This is to certify that Carlson Dale A & Judith A & Tim Boardman
has permission to Removal of non load bearing wall, installation of window sills and some framing.
AT 16 Cumberland Ave L 014 B005001

Permit No: 06-0949	Issue Date: PERMIT ISSUED JUL 13 2006	BL: 014 B005001
-----------------------	----------------------------------------------------	--------------------

Past Use: Four (4) residential condominium dwelling units <i>Legal use: 4 res. condos</i>	Proposed Use: Within one Condominium / Removal of non load bearing wall, installation of bay window, skylights and some framing. (Amendment to permit # 060569)	Permit Fee: \$39.00	Cost of Work: \$1,800.00	CEO District: 1
Proposed Project Description: Removal of non load bearing wall, installation of bay window, skylights and some framing.		FIRE DEPT: <input type="checkbox"/> Approved <input type="checkbox"/> Denied <i>N/A</i>	INSPECTION: Use Group: <i>R2</i> Type: <i>SB</i> <i>7/12/06</i>	
		Signature: <i>Carole Guise</i>	Signature: <i>Cliff Coughlin</i>	
PEDESTRIAN ACTIVITIES DISTRICT (P.A.D.)				
Action: <input type="checkbox"/> Approved <input type="checkbox"/> Approved w/Conditions <input type="checkbox"/> Denied				
Signatu

EXHIBIT D

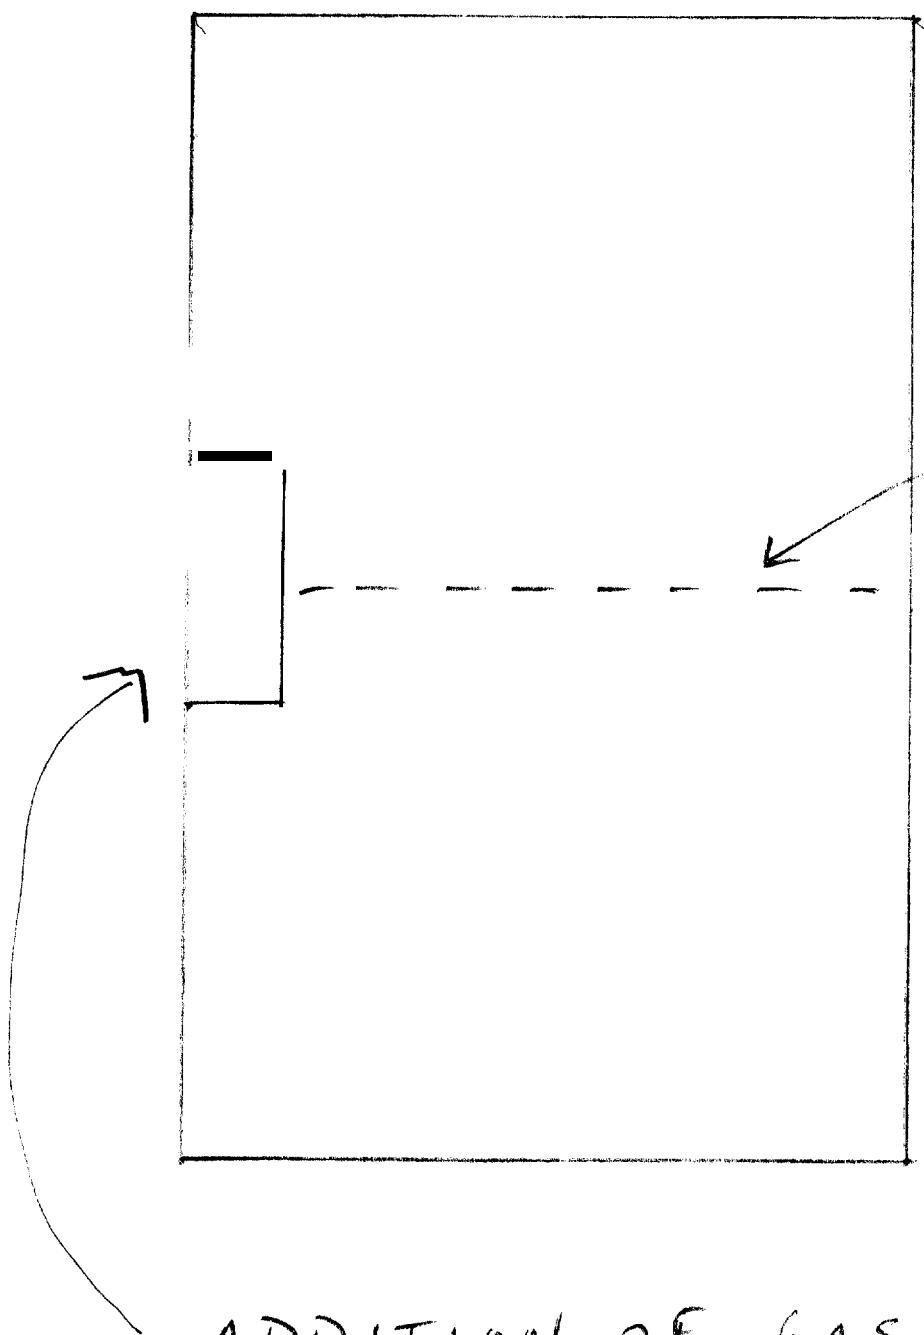
- 1) A separate permit is required for the Gas Fireplace.
- 2) If the existing casement windows do not satisfy emergency escape standards, the skylights must. This must be verified prior to installation of the skylight.
